RE: SUBMISSION TO SYDNEY METRO ENVIRONMENTAL IMPACT ASSESSMENT MODIFICATION

Please find attached North Sydney Council's submission to the Sydney Metro City and Southwest Environmental Impact Statement Modification **SSI 7400 MOD 1**, exhibited from 7 June 2017 to 5 July 2017.

Submission to Sydney Metro City and Southwest Environmental Impact Statement Modification

Figure 1: Proposed relocation of Victoria Cross northern services building, additional access and construction site (Source: Victoria Cross Station and Artarmon Substation Modification Report, TfNSW 2017)

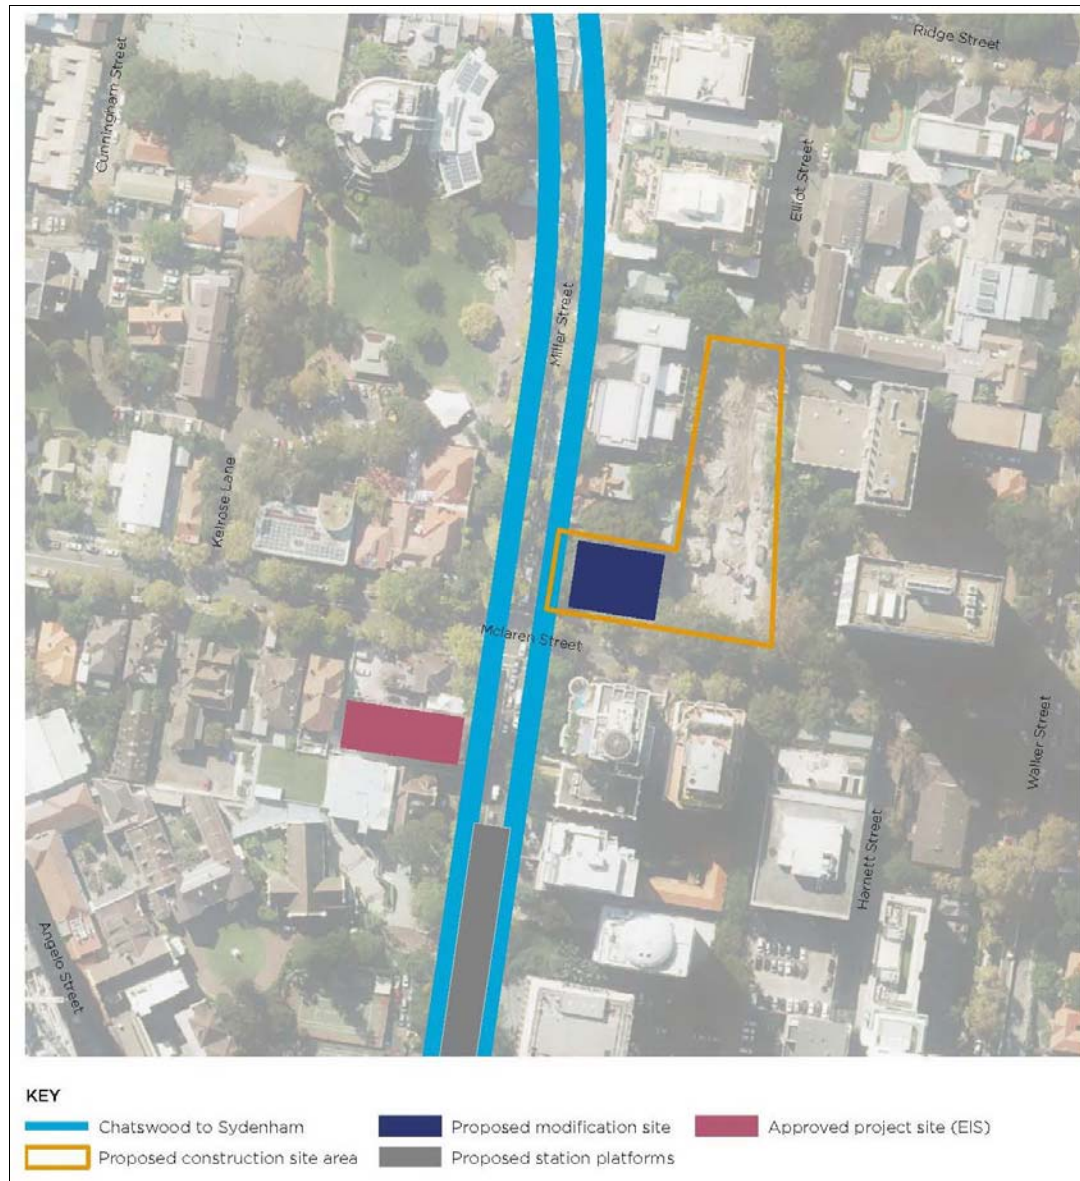
Council supports the proposed entry plaza to Miller Street. Consideration should be given, however, to an additional eastern access to better connect with nearby schools, hotels, the Ward Street precinct, and a future through site link over No. 52 McLaren Street. Doing so will also mitigate the constraint posed by the steep gradient of McLaren Street adjacent to the northern access site.

Figure 5 Proposed haulage route for Victoria Cross northern services building (Source: Victoria Cross Station and Artarmon Substation Modification Report, TfNSW 2017)

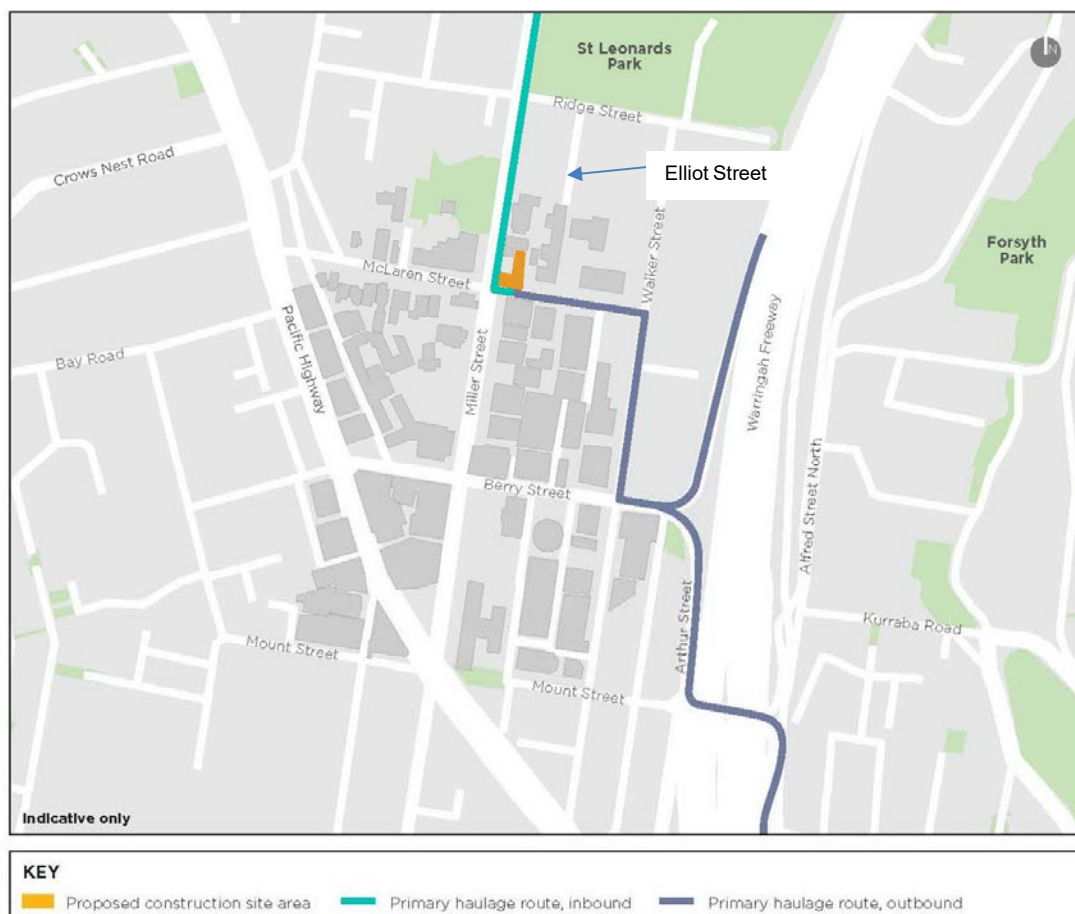
The Modification Report proposes that trucks exiting the northern construction site will access the Warringah Freeway via Walker Street. It is noted that Walker Street is a local road and is not suitable for larger trucks with trailers. Large truck movements should be confined wherever possible to arterial roads.
